Smart Motorways Programme

M4 J3 - J12

Acoustic Barrier Changes
Technical Note

Document Number: HA514451-CHHJ-HFE-S1_ZZZZZZZZ_Z-TN-KK-0001

Drawing title  
**ENGINEERING AND DESIGN**  
**REPORT MAINLINE**  
**GENERAL ARRANGEMENT**  
**SHEET 11 OF 61**

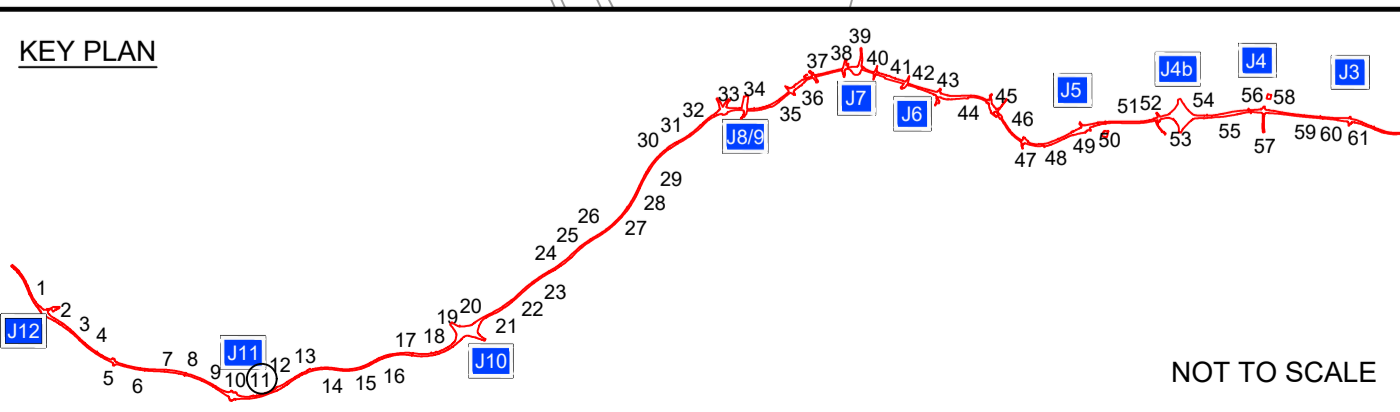
There is an existing 3 metres high barrier outside the motorway boundary and behind the proposed noise barrier location for EM6 (approximate Ch. 53902 to 53650 and on sheet 11 of the Environmental Masterplan) which was not included in the original noise model.

Additionally, it has been noted that the existing barrier in the eastbound verge of the M4 east of J11 (approximate Ch.53902 – Ch.54130) was defined in the DCO submission as a 1.8-metre-high solid noise

barrier. Subsequent further survey work has shown that, moving east from where the existing acoustic

barrier changes offset to be closer to the B3270, there is 14 metres of existing 2-metre-high acoustic barrier

in good condition, after which the fence is a 1.5-metre-high open wooden slat fence between Ch.53963 –

Ch.53902 which is not expected to provide any acoustic attenuation.

It is concluded that the proposed 2 metres high noise barrier to the motorway would not provide any significant noise reductions and would not be value for money. Consequently, EM6 can be removed from the new noise barrier provision for the Scheme without changing the conclusions of the assessment presented in the Environmental Statement.

Drawing title  
**ENGINEERING AND DESIGN**  
**REPORT MAINLINE**  
**GENERAL ARRANGEMENT**  
**SHEET 13 OF 61**

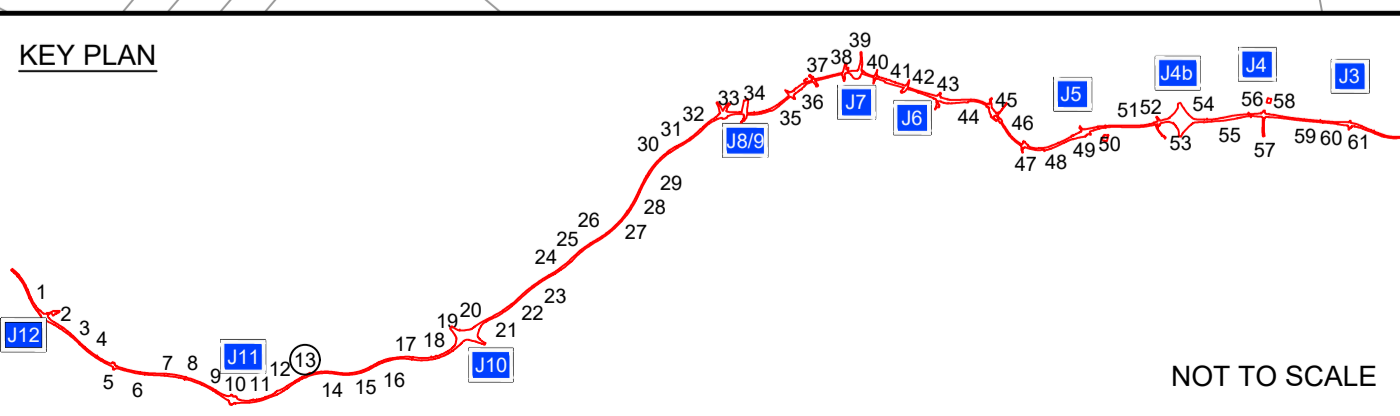
The noise model has been revised to examine the effects of reducing the length of the western section of barrier EM8 (approximate Ch.51820 – Ch.52720 and on sheets 12 and 13 of the Environmental Masterplan), the reduction in length being at the western end of the barrier.

It is concluded that barrier EM8 can be shortened by 150 metres at the western end without changing the conclusions of the assessment presented in the Environmental Statement.
